PLANNING APPLICATION REPORT**REF NO:** R/278/10/**LOCATION:** 40 Broadmark Lane
Rustington**PROPOSAL:** Construction of a vehicular crossing**SITE AND SURROUNDINGS**

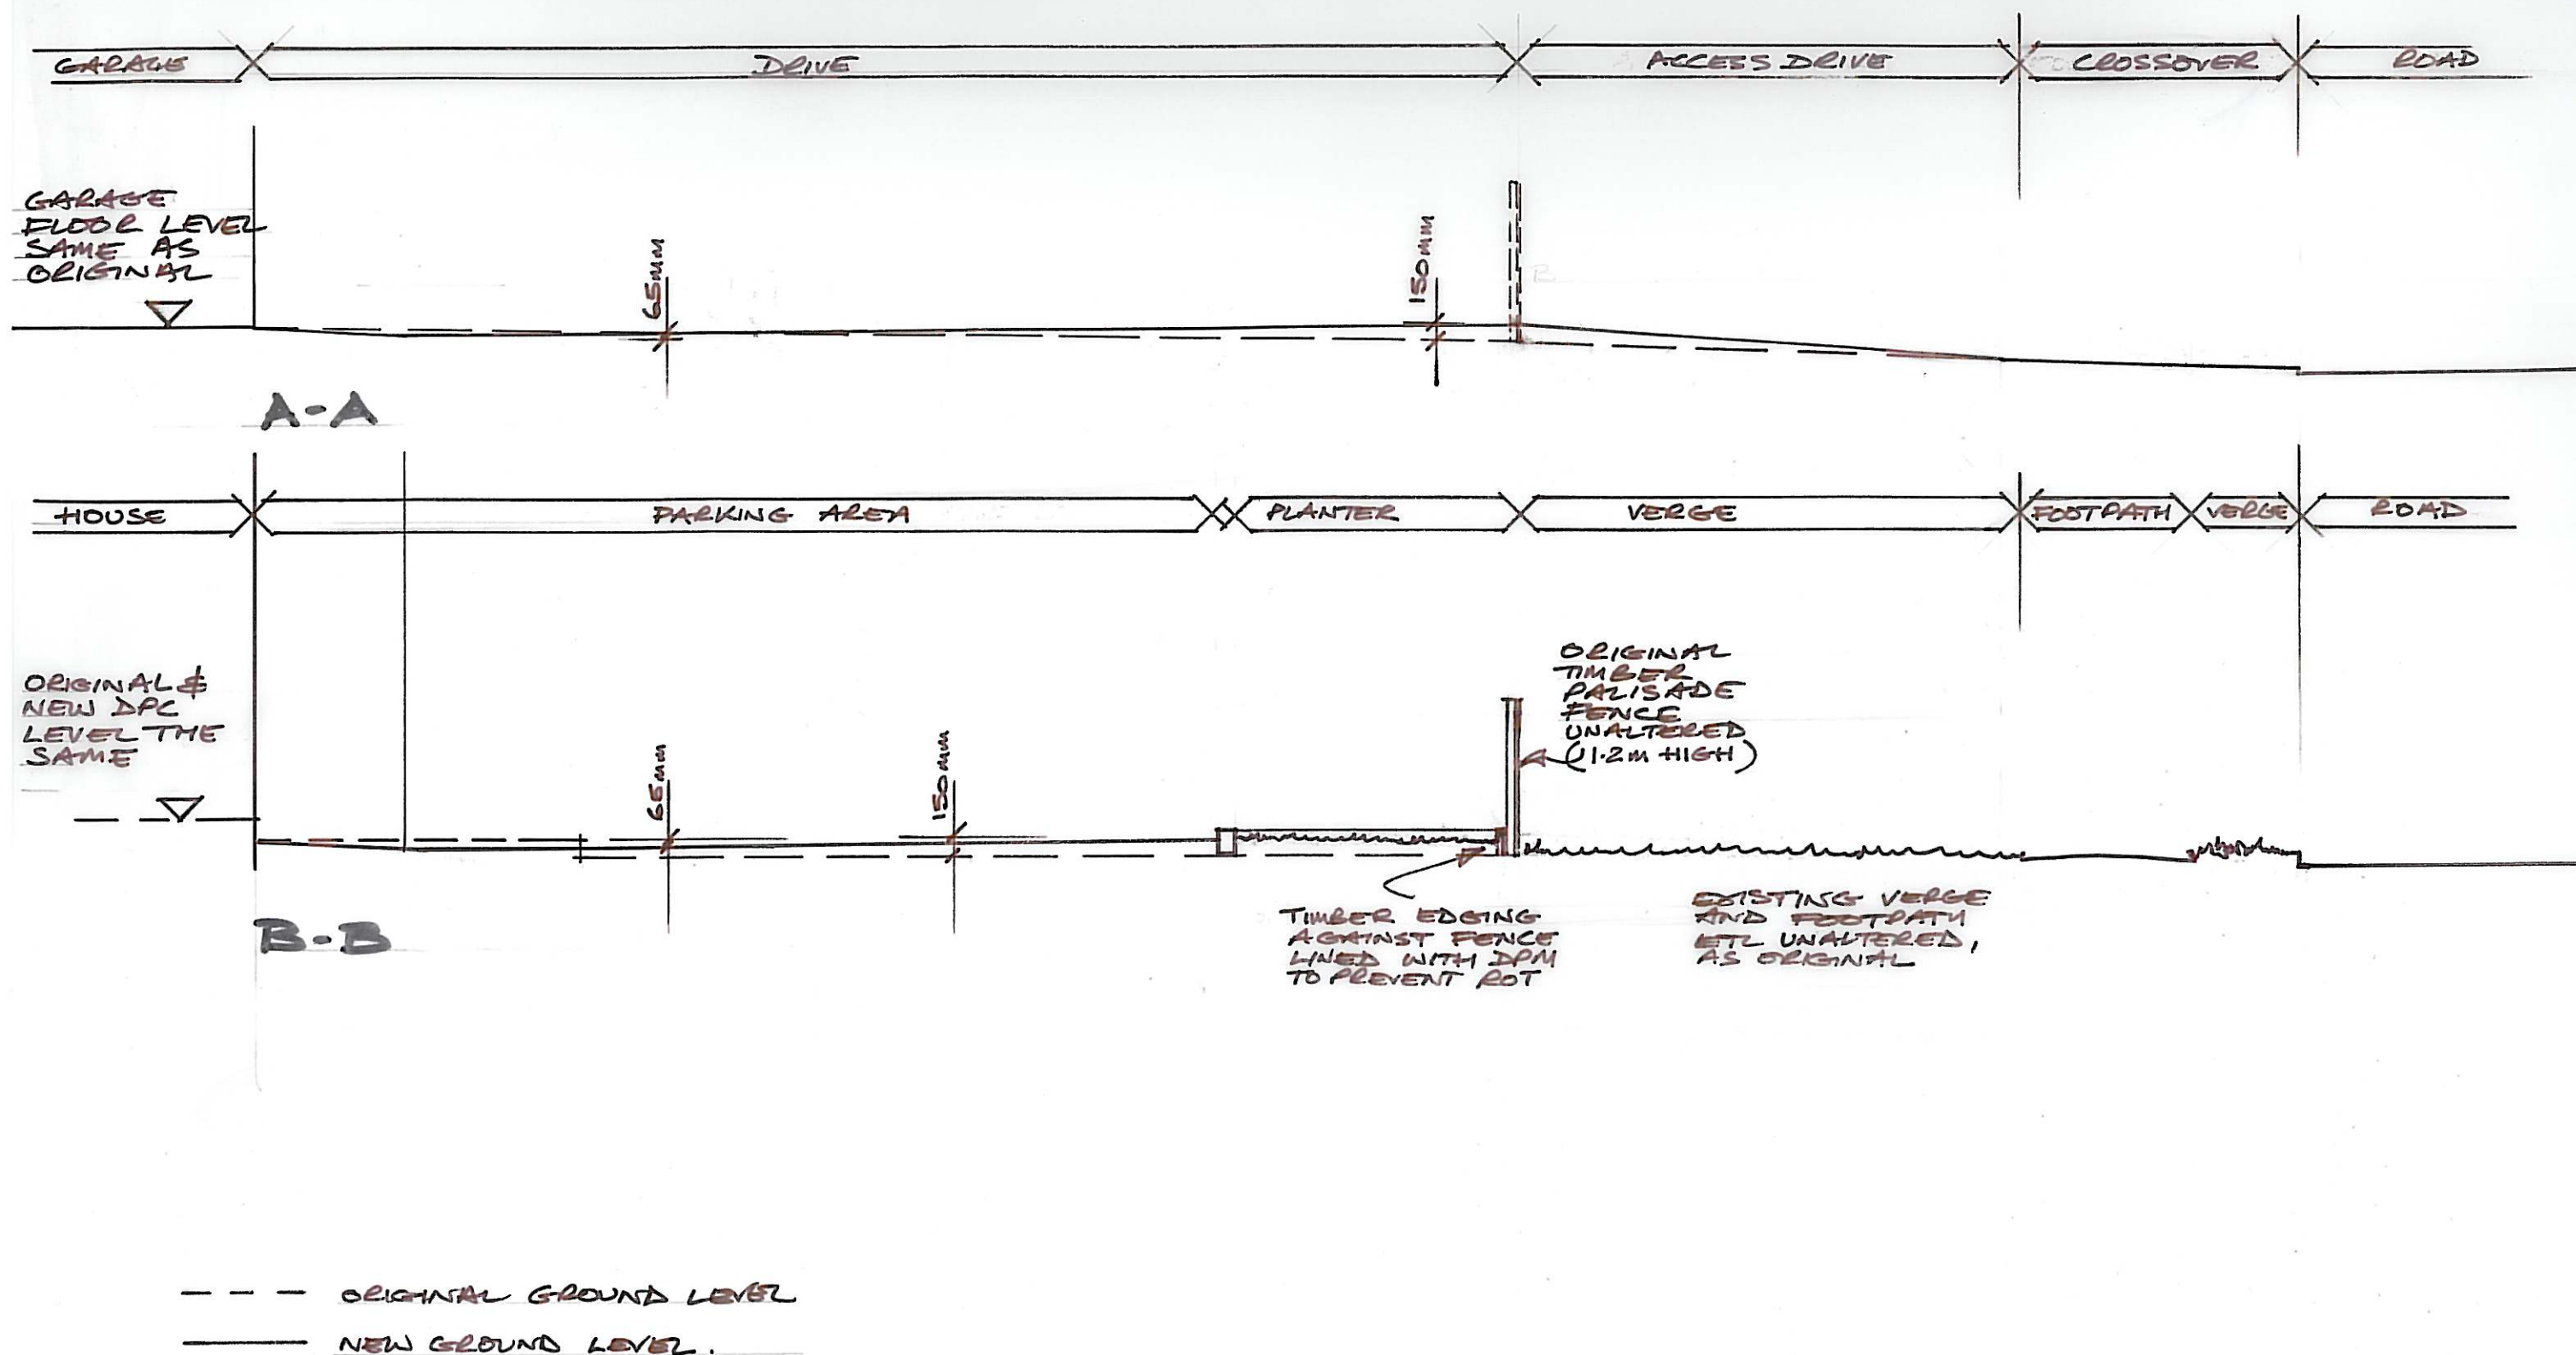
No highway safety objections to the retrospective vehicle crossing subject to the access being constructed from a bound material for the first 5m from the highway and surface water is to be discharged on the owners land. Pedestrian visibility splays of 2m x 2m to be secured, therefore the access should be modified to comply with this requirement.

- 3 Within 2 months of the date of the decision the retaining red brick walls to either side of the ramped crossover shall be reduced in height so that the top of the brick coping is at the same level as the ramped access.

Comments noted. Existing material together with the removal of the retaining brick walls and drainage of the driveway is considered to be acceptable. Condition to be included with any approval with the requirement for 2m x 2m pedestrian visibility splays.

- 2 Within 2 months of the date of the decision details of pedestrian visibility splays shall be provided and within a further 2 months any associated works if required shall be undertaken and thereafter permanently retained.

2 metres by 2 metres on each side of the proposed access based on the existing highway boundary.
